Our Ref: EN010012

Date: 25 February 2021

Application by NNB Generation Company (SZC) Limited for an Order Granting Development Consent for The Sizewell C Project

Request for further information

DRAWING TITLE:
MAIN DEVELOPMENT SITE SSSI CROSSING
(UNDER CONSTRUCTION - BAILEY BRIDGE STAGE)

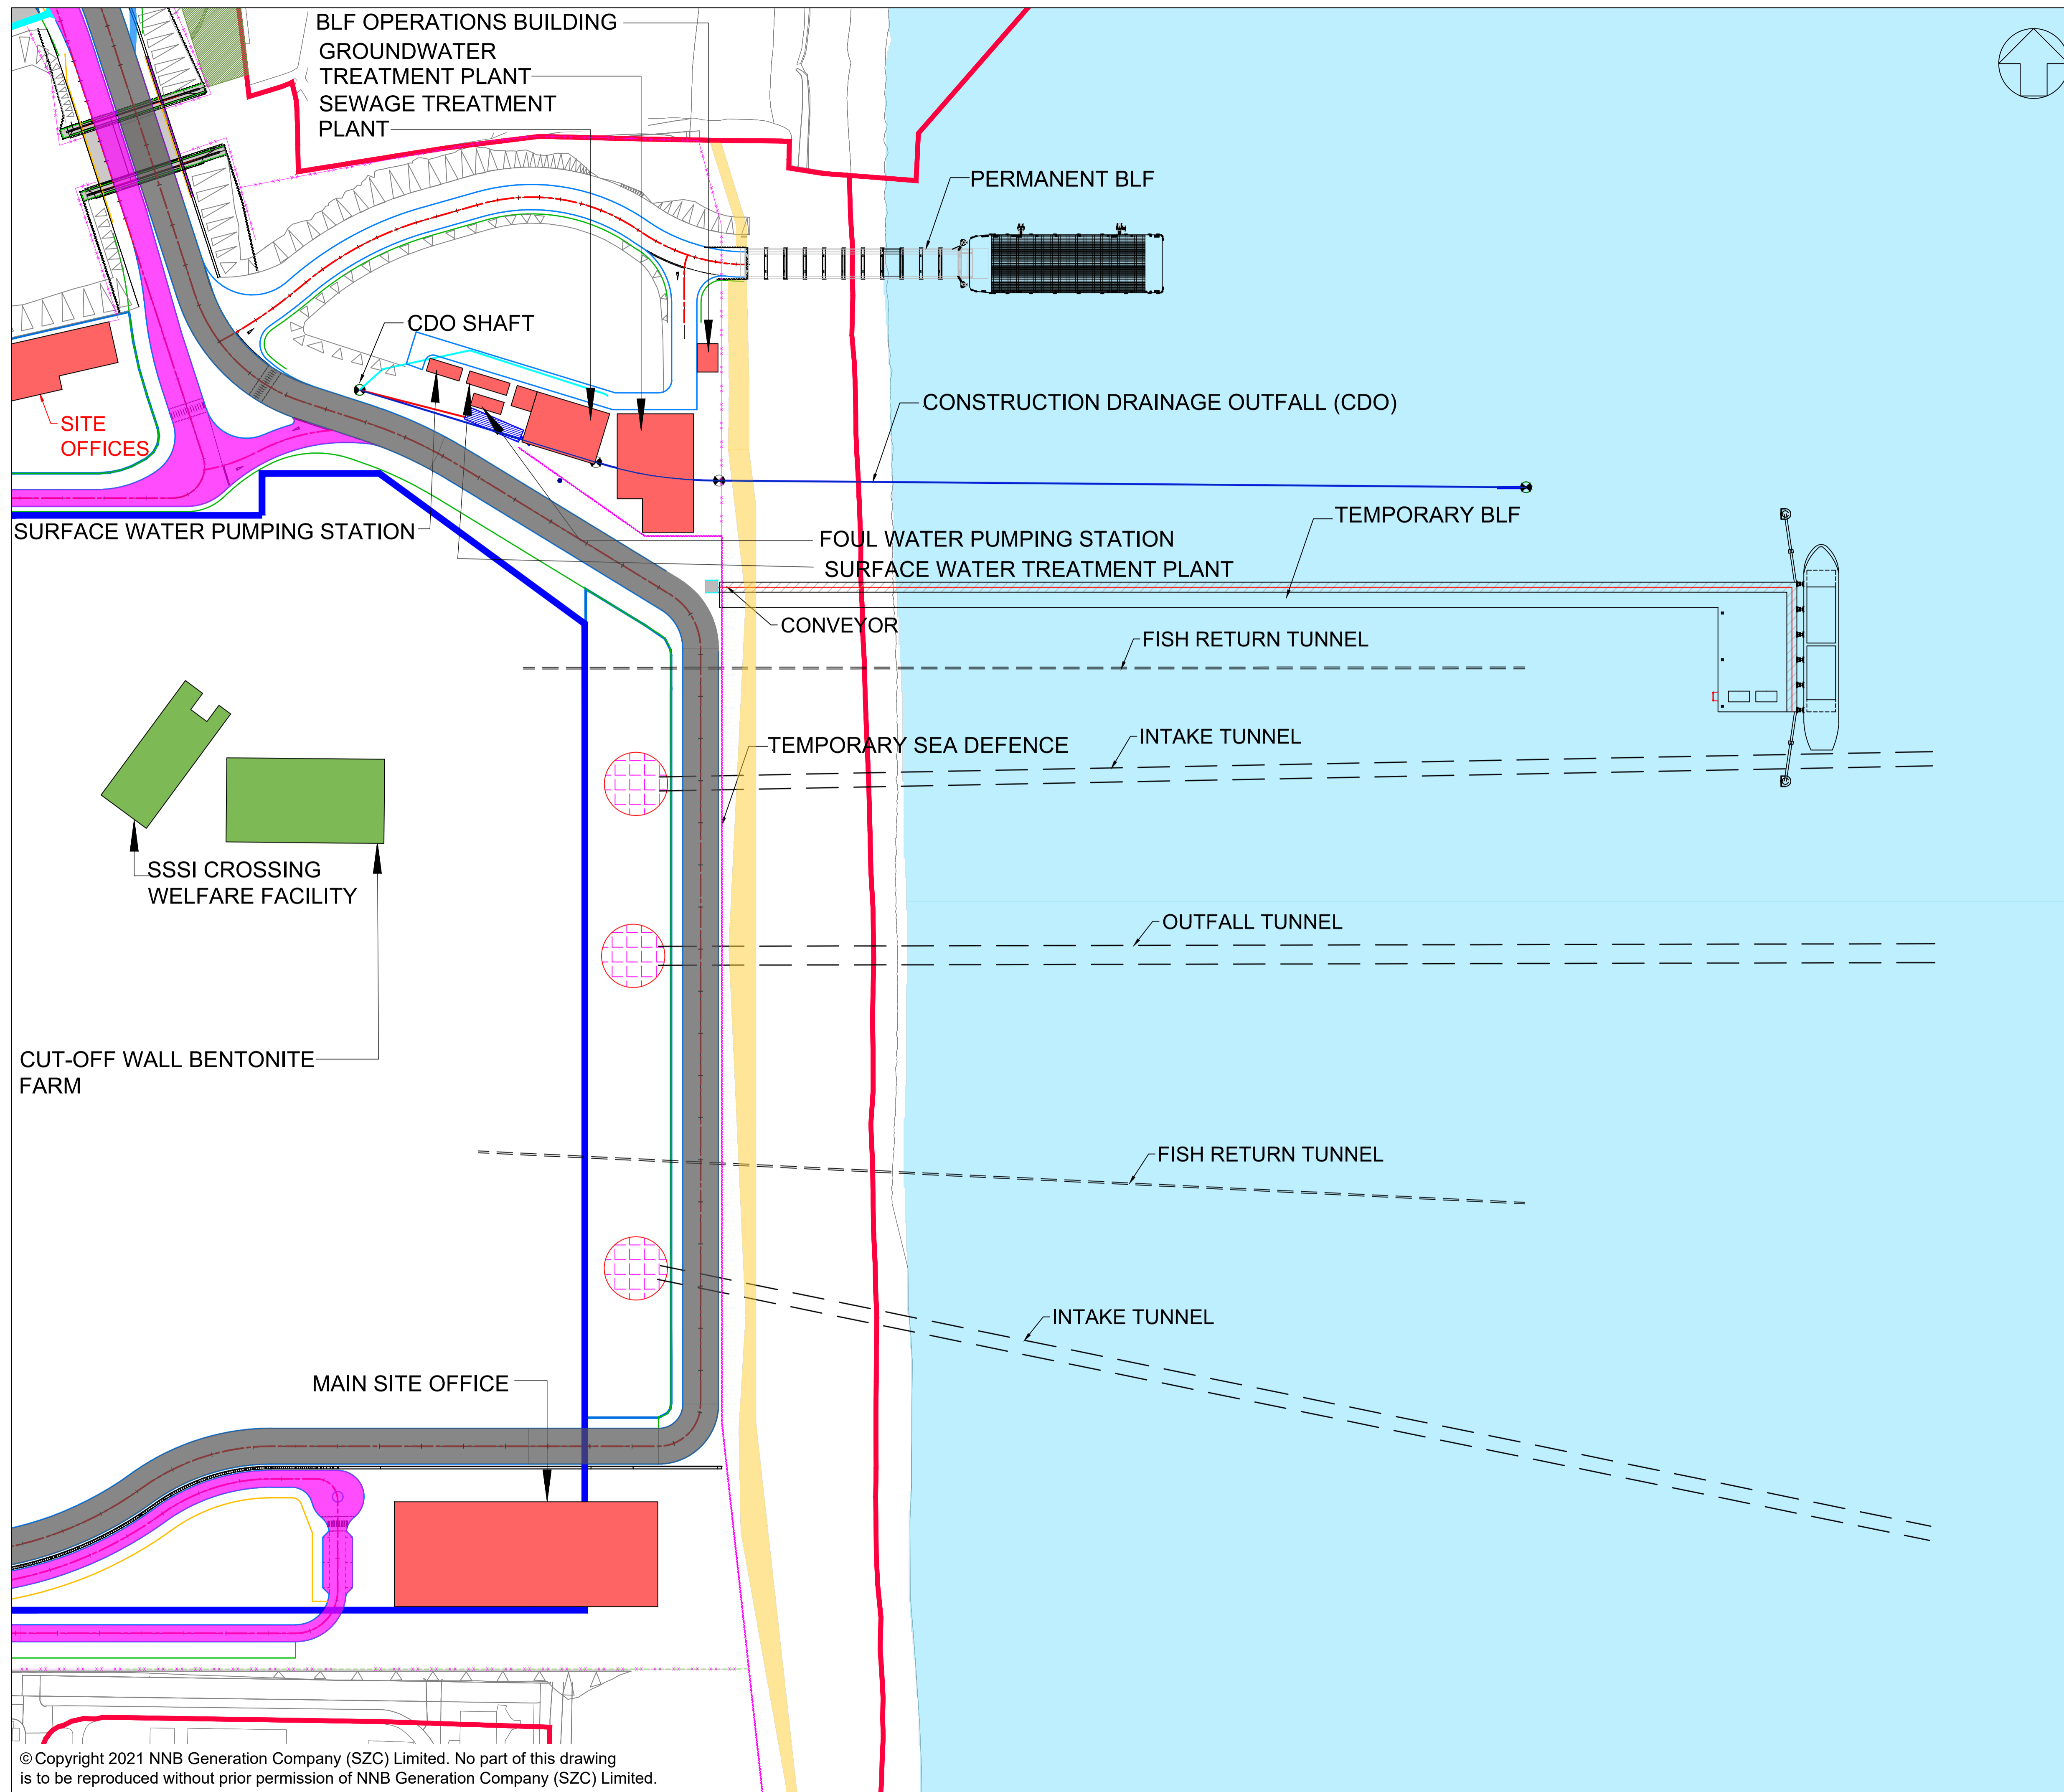
- A detailed plan of the permanent crossing of the SSSI and its connection to the main site;
- A detailed plan of the SSSI crossing showing the additional temporary haul road in place.
- A detailed plan showing the temporary bailey bridges
- A cross section perpendicular to the longitudinal section that is shown in Plate 3.2 in [[AS-157](#)];
- A permanent access road cross section showing the widths of carriageway and locations of the barriers to correct scale;
- A representative view / elevation of the crossing from the west side looking east; and
- If lighting is proposed to be provided a revised version of Figure 2.2.15 in [[AS-190](#)] and related views/ sections requested above.
